Online Comment

Application H02-0670-26
Location The Manor House 5 East Street Crowland PE6 0EN
Proposal Alterations to the rear service wing allowing for rebuilding of chimneystack, structural repairs to gable end, replacement of rainwater goods, rebuilding of single storey structure, works to garden wall & internal works

Name Gregory Watkinson, Principal Conservation Officer
Address Council Offices Priory Road Spalding PE11 2XE

Date Submitted 07-09-26
For/Against Comments

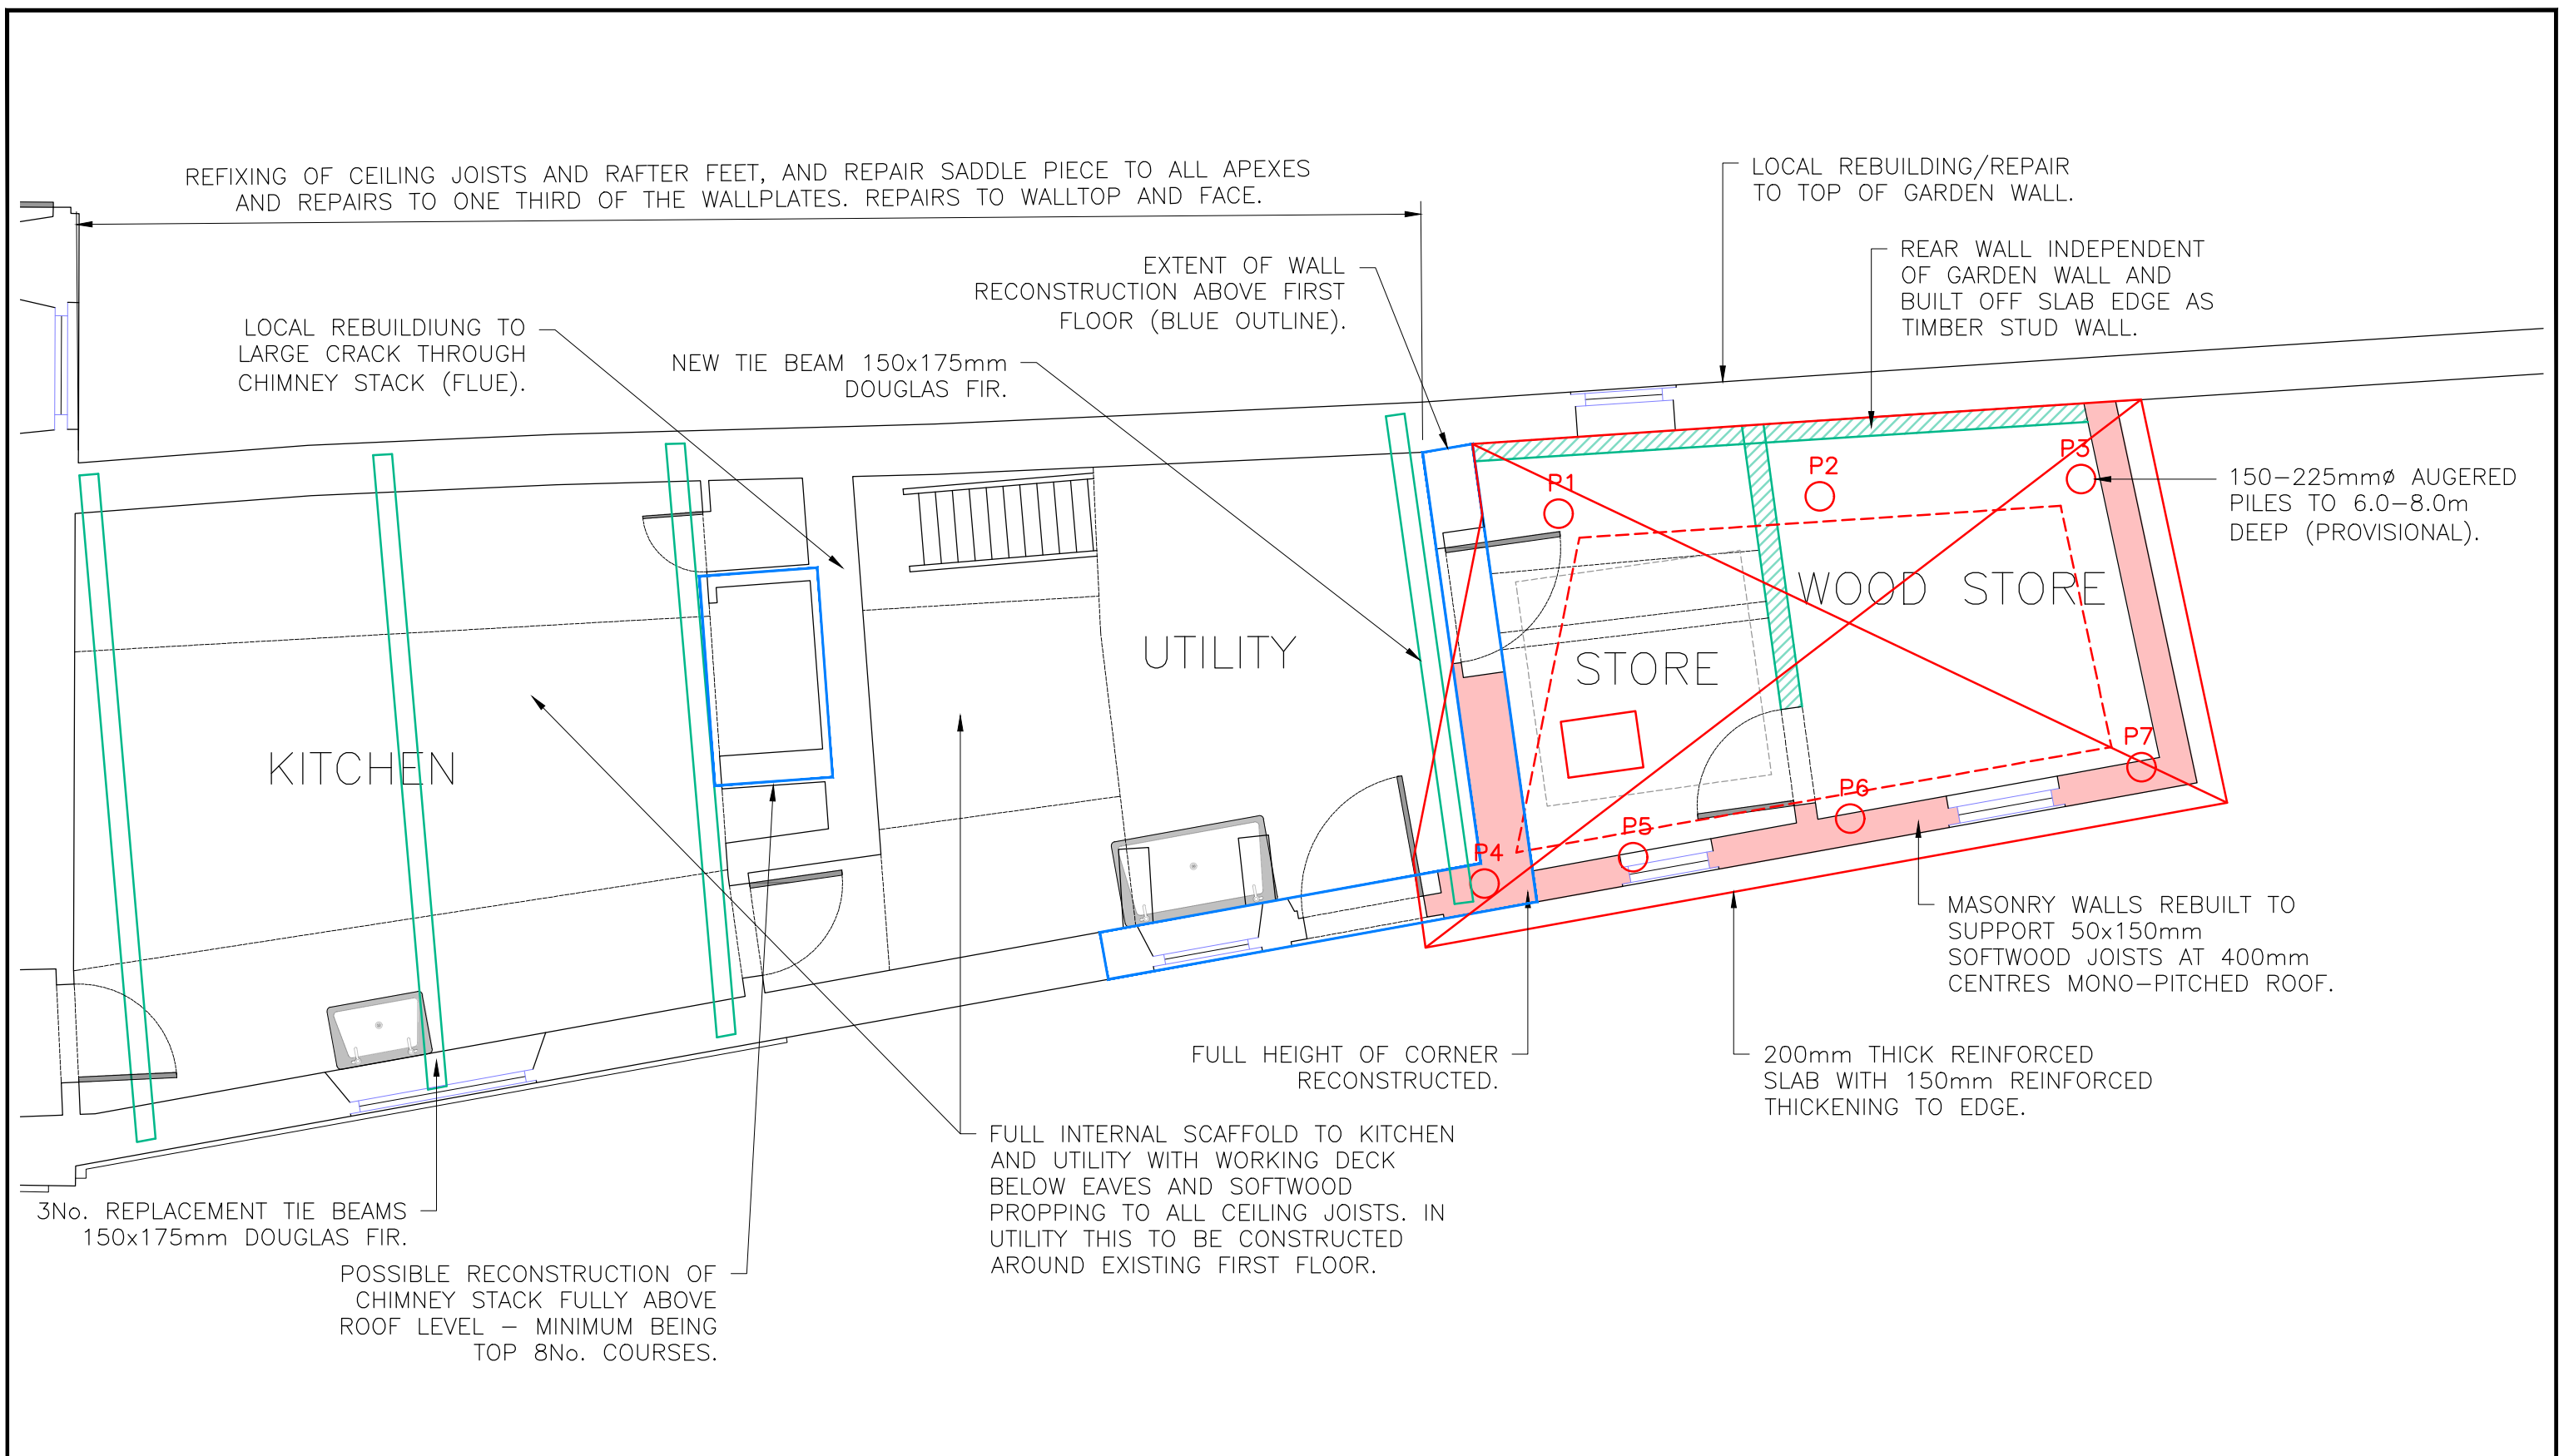
Moreover, in line with the recommendation of Historic England, an informative condition should be applied informing the applicant that should the works necessary to repair the south gable of phase E deviate from those included in drawing 22757/R/30 or the Statement of Justification for Structural Repairs, that the applicant or their representatives should contact the SHDC planning department's conservation specialist prior to those works taking place to discuss if those deviations require separate consents.
